Engineers Comments Regarding Surface Water Drainage

Application Reference:	WA/50/25/DOC	Reviewer Reference:	ADC/EXT4
Planning Officer:	Amber Willard	Date of Review:	11/12/202
Site Name:	Fleurie Nursery Lake Lane Barnham PO22 0AL		
Application Description:	Approval of details reserved by condition imposed under reference WA/75/20/PL relating to condition number 3 - surface water drainage scheme, condition number 4 - surface water drainage system and condition number 7 - surface water drainage scheme.		
Assessment Number:	2 of 2

Non SE orifice plate
discharge details
(North, East, SW).

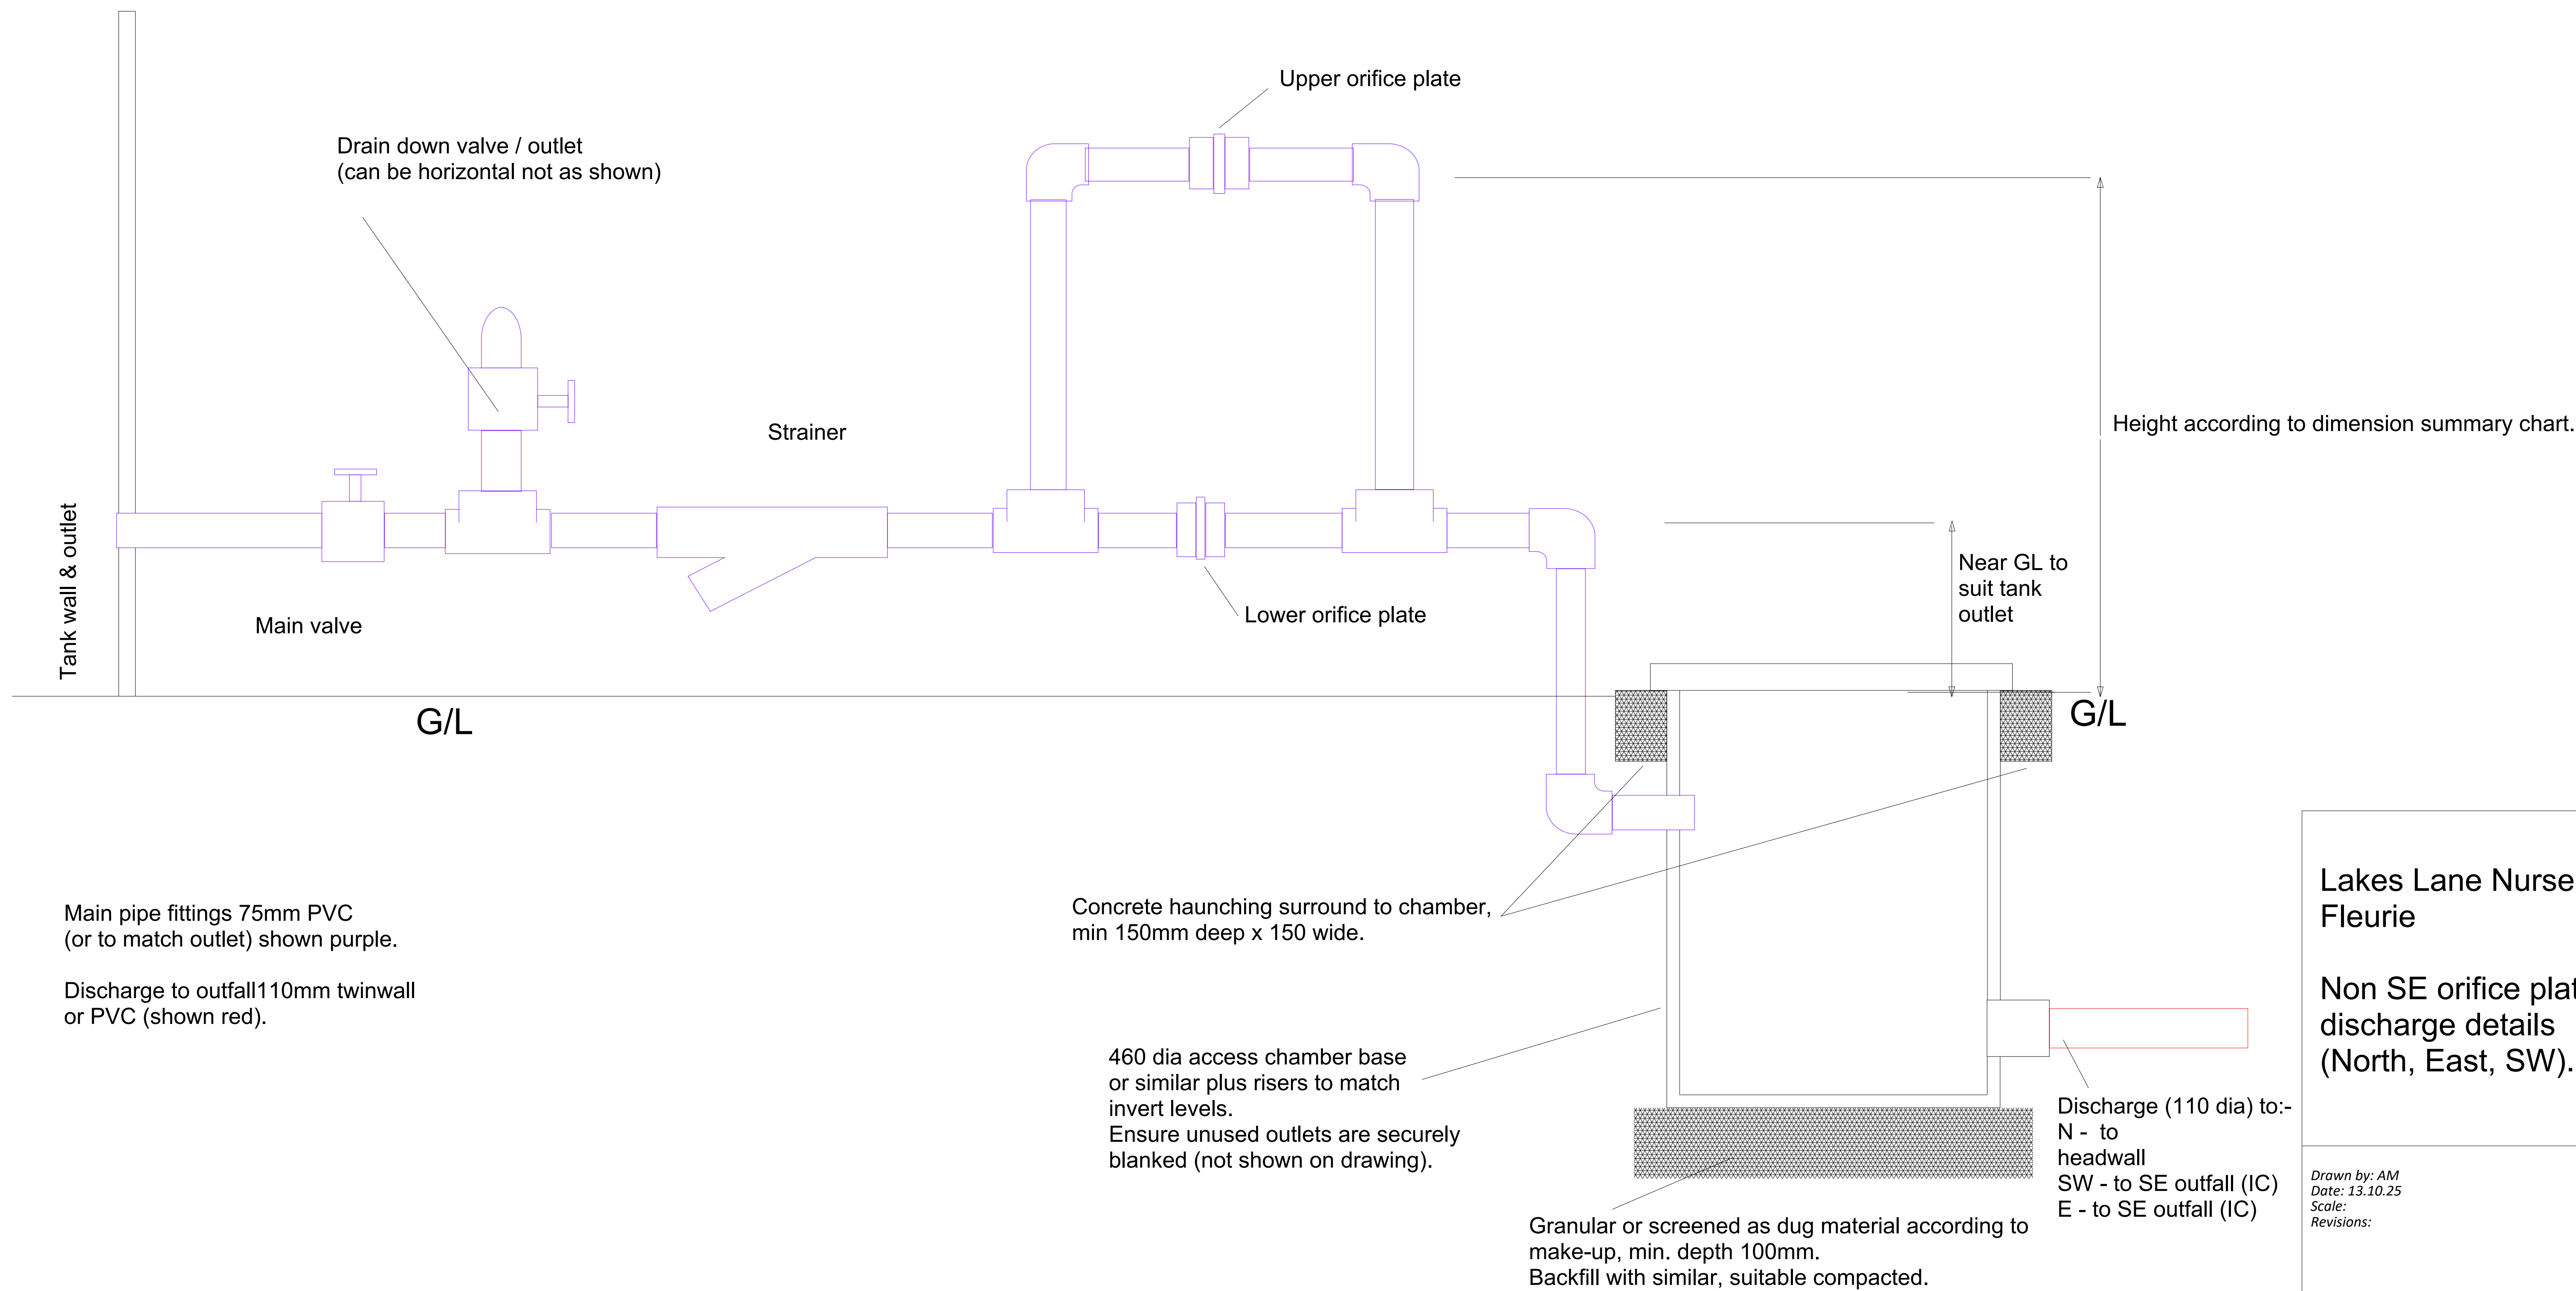
8	Please provide construction details for orifice flow controls. The construction details should clearly show how these are fitted within the flow control chamber and	"See attached drawing "Orifice plate outlet detail". The installation is straightforward, with a tank connector from the attenuation tank connected to a pipe (all pipework	Thank you Please provide specific level information on this orifice plate detail. I.E cover level, invert level etc....

relationship with drainage network	75mm PVC glued or threaded joints) passing through an isolating valve, then a T piece for connection to draindown valve (maintenance) and thence t a strainer (filter) and to the T where the flow will normally exit through the lower orifice plate, but as levels in the tank rise to above the upper orifice plate then through this too. Orifice plates are stainless steel with EPDM gaskets (both sides) and clamped in position by the flanges it is mounted between, with coupling bolts to hold it in situ. The outlet from the plates goes to an inspection pit, with low level exit (110mm dia) to the discharge outfall."			
9			It appears in some instances that both the bunds and tanks may impede on maintenance easements associated with the existing watercourse. Please provide a clear plan indicating required 3m easements to existing watercourse within the site.		
Condition Number: 4

North exceedance  
Bund area and level

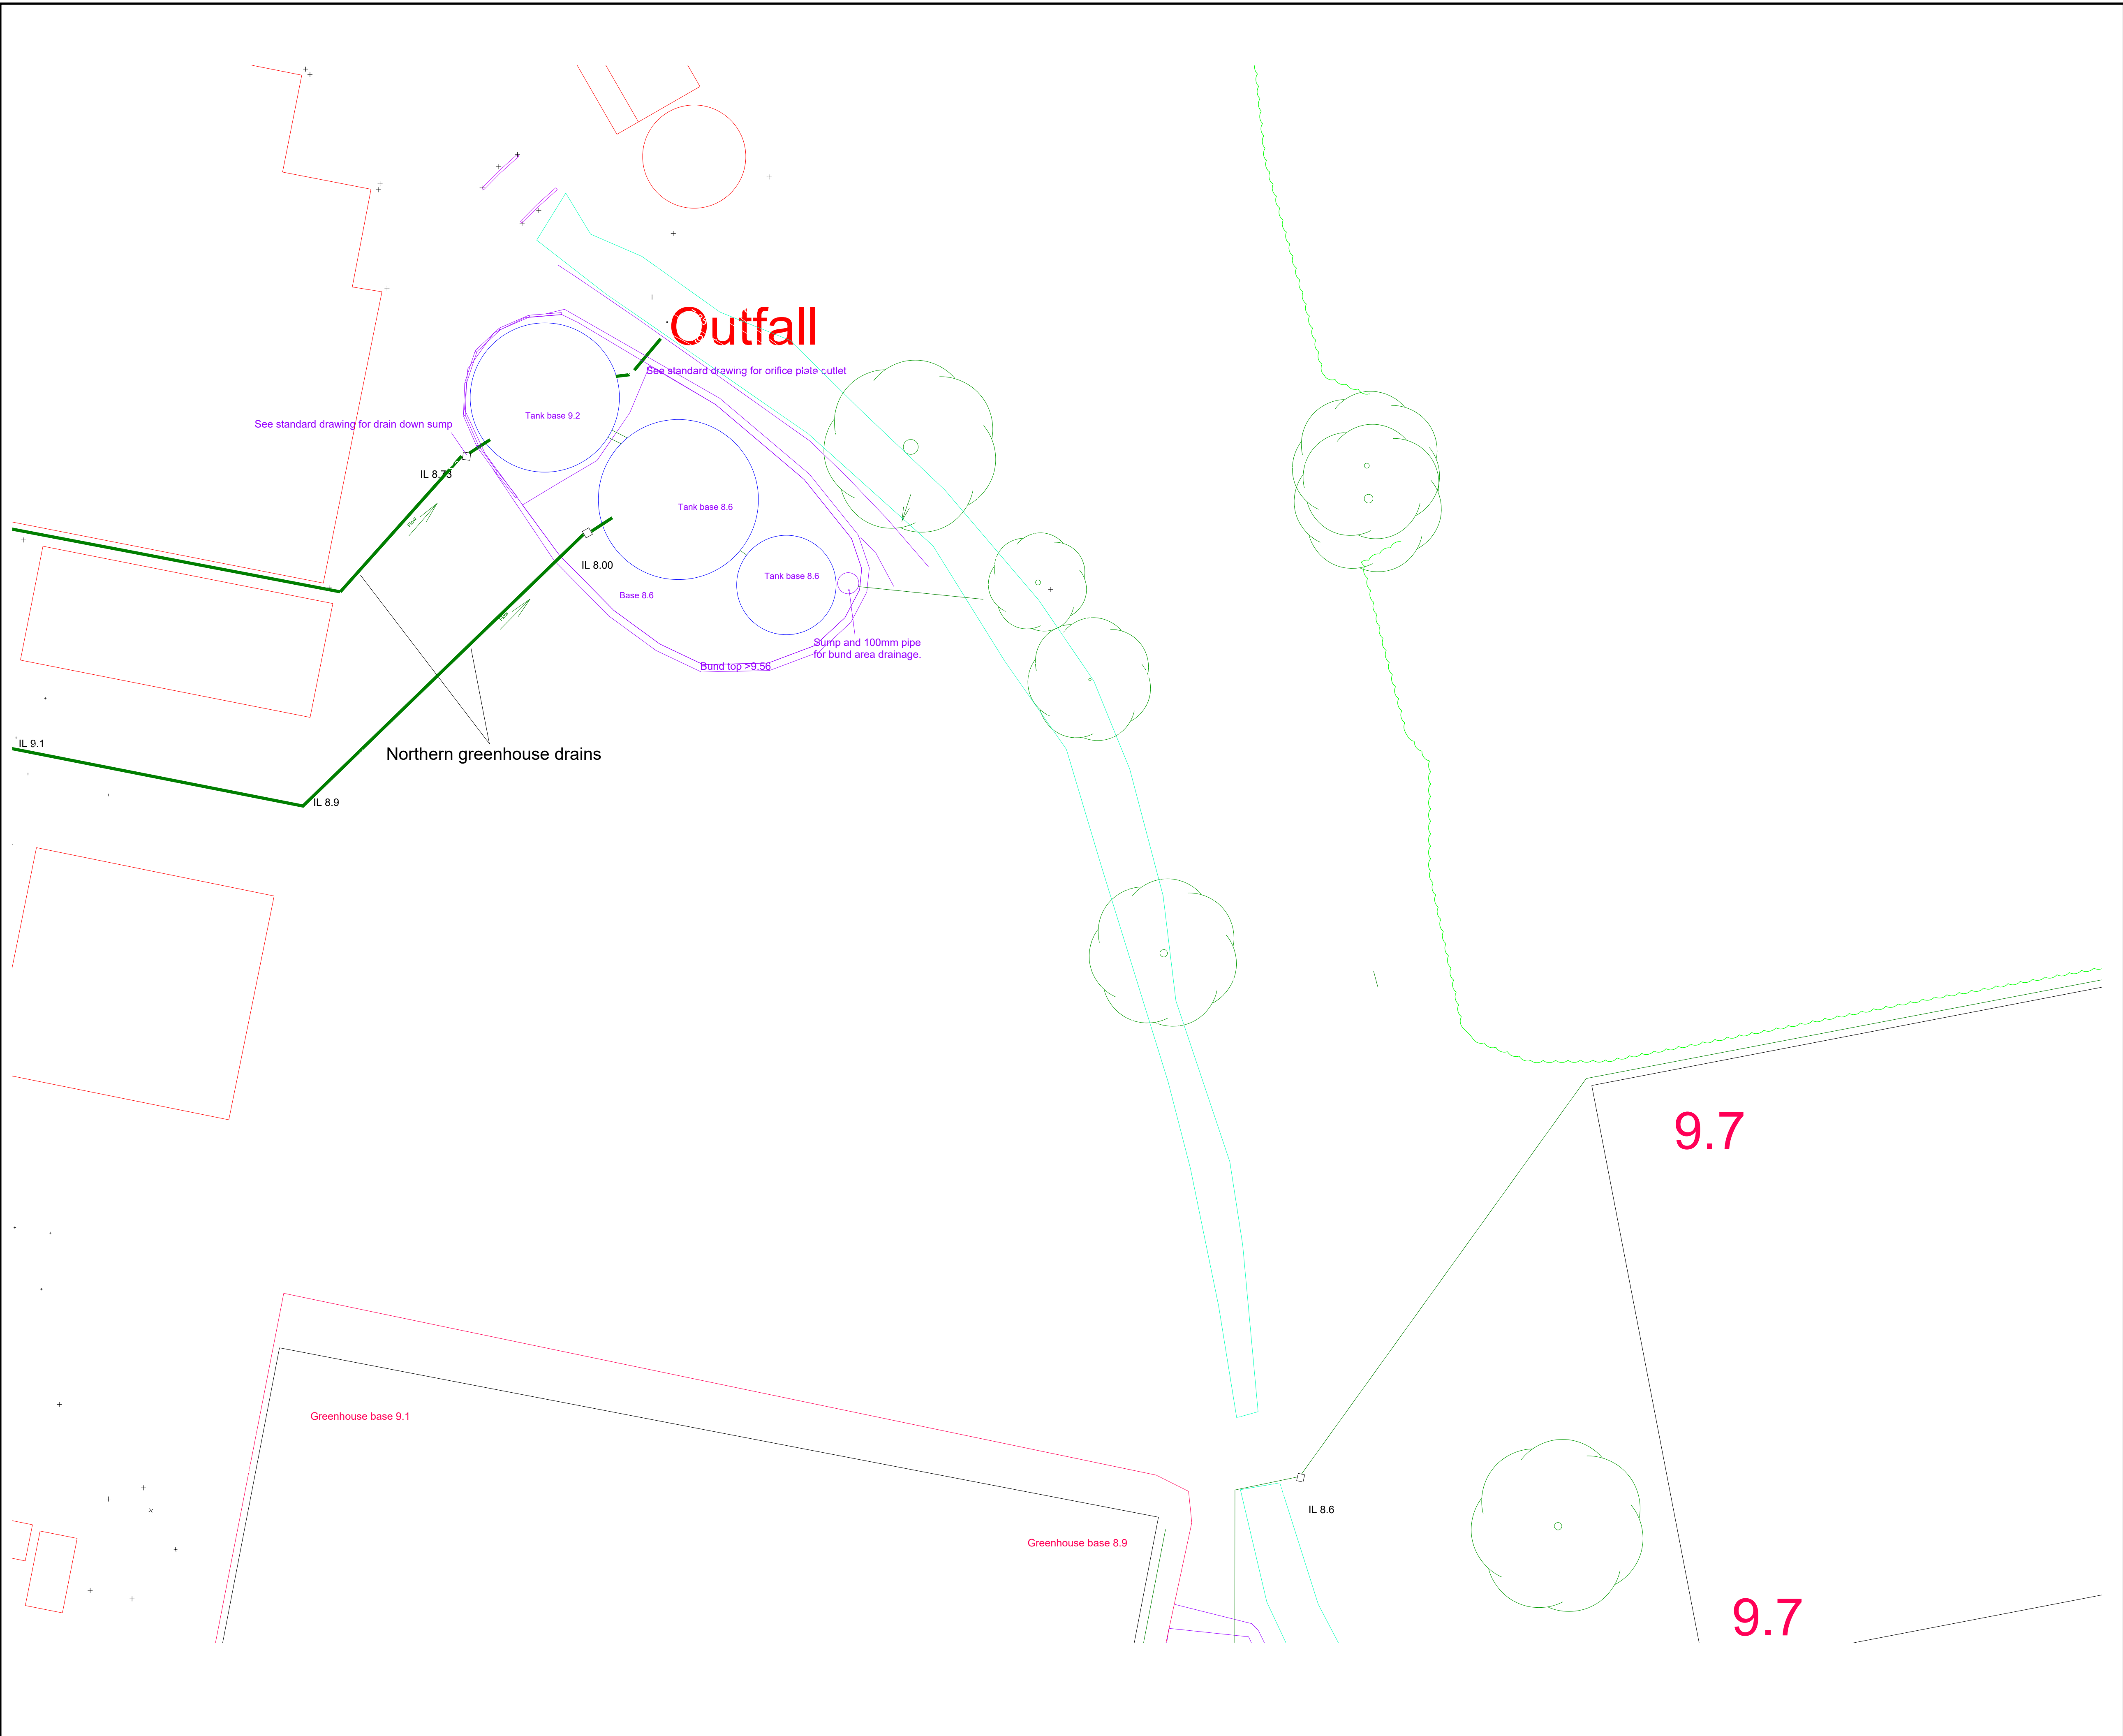
visible flow into the attenuation tanks. Experience and reason also dictate that for a large bore pipes with solely clean water in large volumes going along them blockages are not likely to occur. Self propelled CCTV inspection devices can reach 200m from entry, and none of our runs are as long as this so this is not a problem if required.			
5	The exceedance flow layouts are unclear. Further information is required on areas of temporary ponding, flow directional arrows etc...	The exceedance in this case is to cater for (a) an event greater than the system capacity (which makes it greater than the 1:100 years event plus 40% for CCA), and (b) catastrophic failure of 1 of the tanks. It is based on impoundment, using the natural levels and earth bunds. This approach has been acceptable to date. The volume required is based on that of the largest tank in the group, and the volume available by the design to achieve this is simply the depth over the area (using battered banks) minus the footprint of the remaining tanks. The	The design and exceedance flow layouts need to be based on either proposed level and or consideration to existing topographic level information as well. Currently the drawings provided appear to have very limited level information provided. Without this information it's unclear on the final direction of exceedance flows

volumes are now shown on the drawings. The required alterations to the exceedance drawings have been made, see drawings "SE exceedance", "SW exceedance", "E exceedance" and "N exceedance".
